Yorkshire Green Energy Enablement (GREEN) Project

**Document 8.28 Applicant's Comments on Interested Parties' Deadline
5 Submissions**

**Final Issue A
July 2023**

Planning Inspectorate Reference: EN020024

SECTION A - LONGSECTION  
Scale 1:500

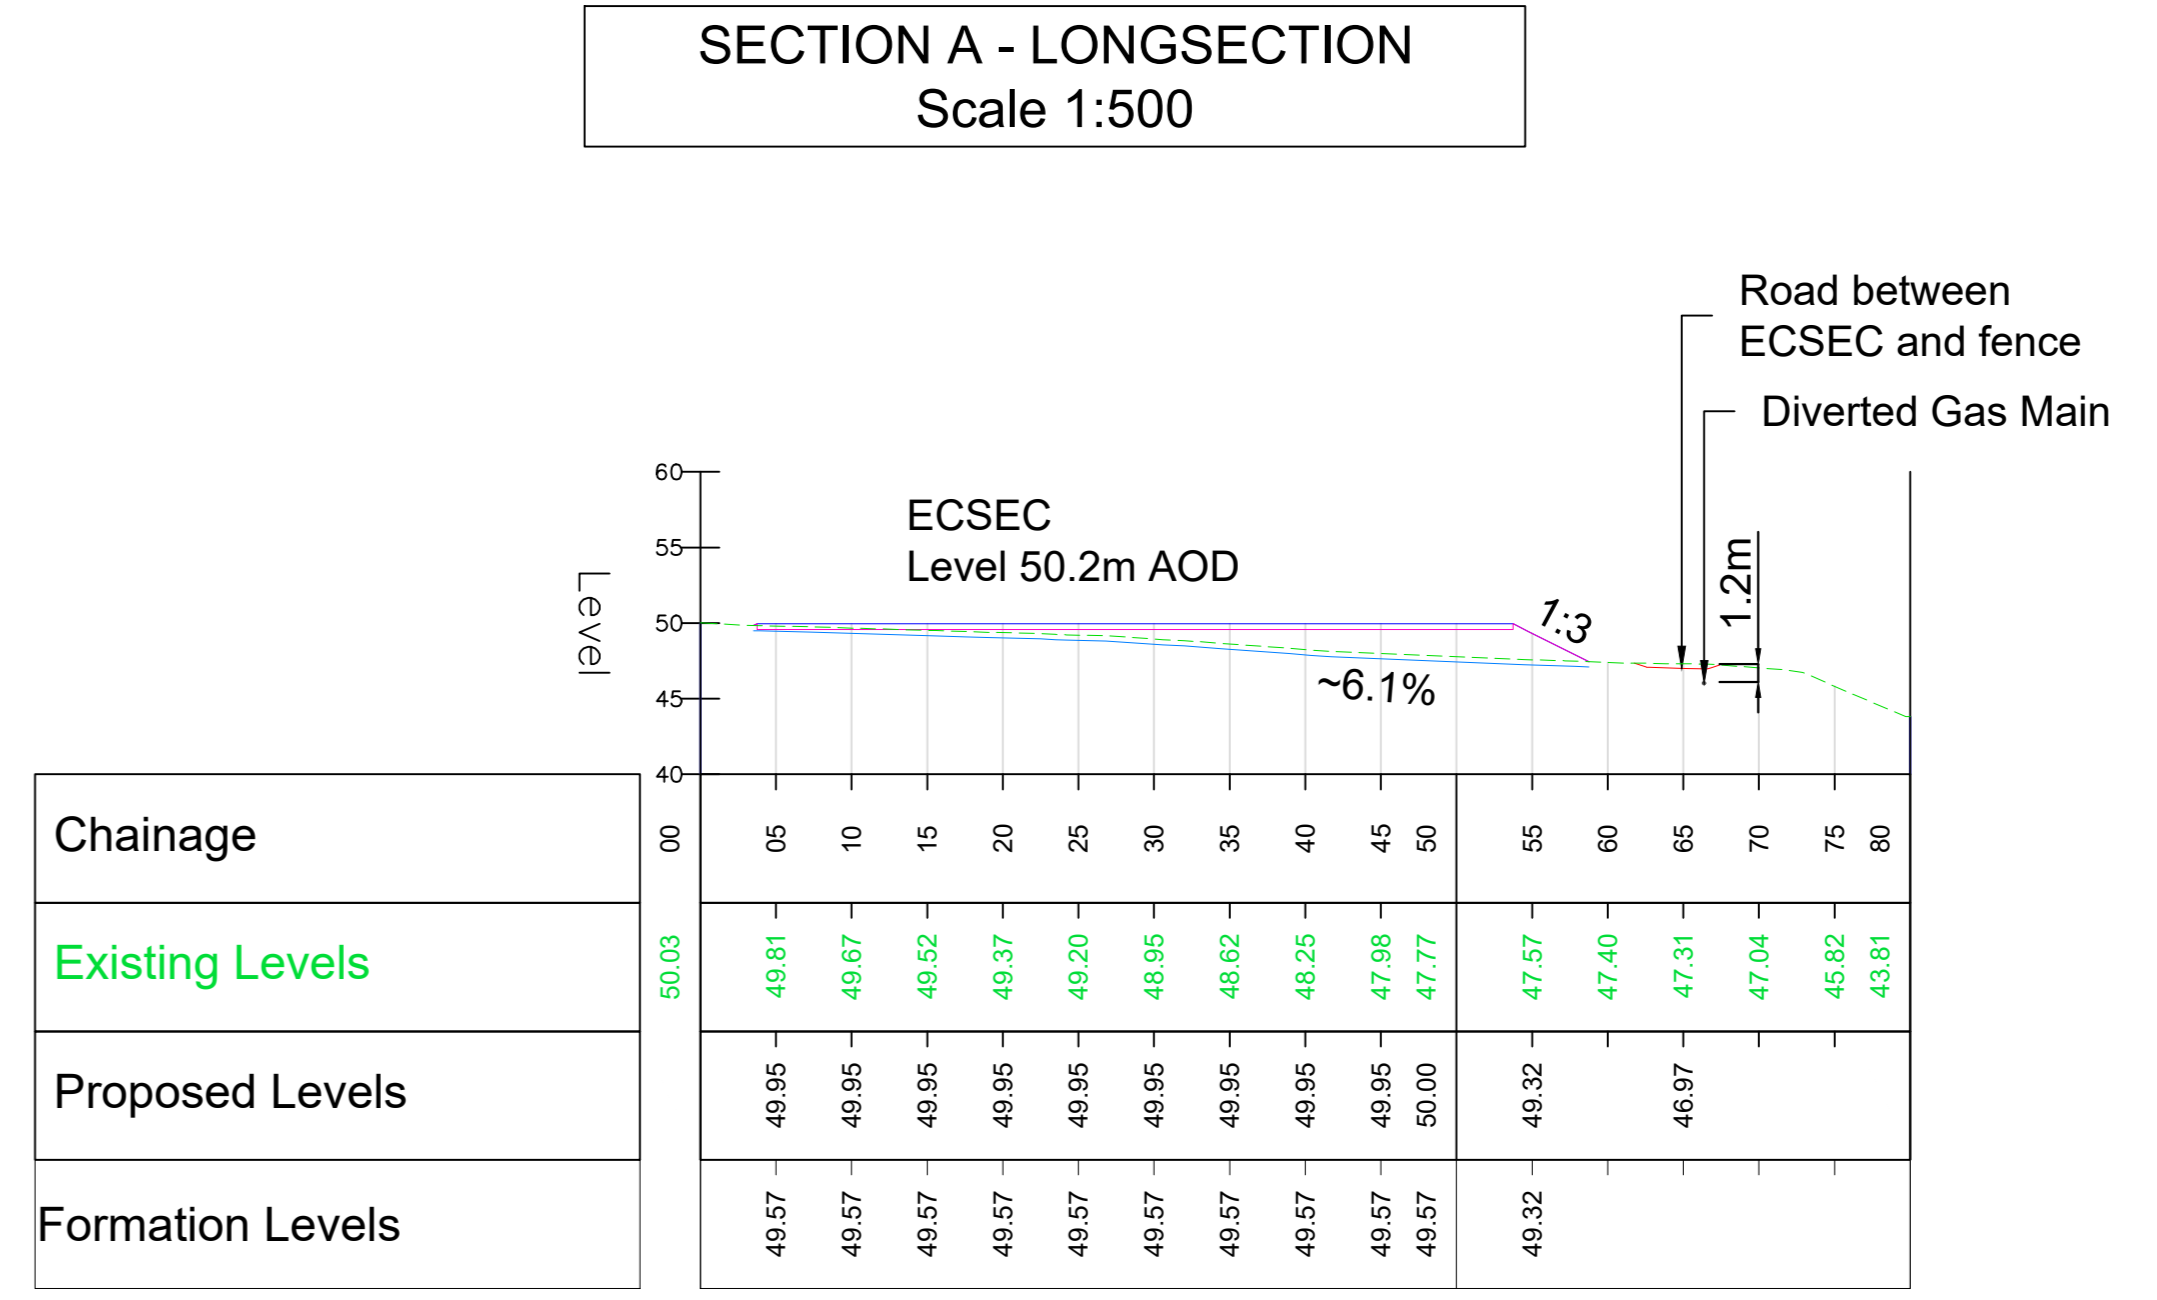
Reference	Topic	Applicant's Response
		<p>retaining wall would not be suitable solution for the use at Tadcaster East CSEC and is not proposed.</p> <p><u>Crop Planting and Access Arrangements</u></p> <p>Access to the landowners field would be maintained with a right granted across the permanent access to the CSEC. Furthermore, National Grid is able to provide a further access gate along the proposed permanent access road to the Tadcaster West CSEC that would enable access to the lower part of the field. This would enable two accesses to the field should two different crops be required to be planted.</p> <p><u>Tadcaster East CSEC – access rights</u></p> <p>The landowner has referenced narrative provided by National Grid in [REP1-015] Table 2.13, Point 13.5 in which National Grid state that <i>should the landowner wish to retain the land despite its restricted accessibility, then National Grid would be willing to agree not to proceed with the acquisition in this part of the Order limits.</i> This statement relates to land to the West of Tadcaster East CSEC and was clear in its intention that this land would have restricted accessibility as National Grid are not proposing any access to this parcel of land. National Grid have included land plot D1-15 as compulsory acquisition as shown on the Land Plan Section D (Document 2.5.4(C)).</p> <p><u>Tadcaster West CSEC Access</u></p> <p>National Grid requires unrestricted access for the operation and maintenance of the cable sealing end compound, and to that extent would need to ensure that fly tipping and unauthorised parking in the bellmouth be prevented at all</p>
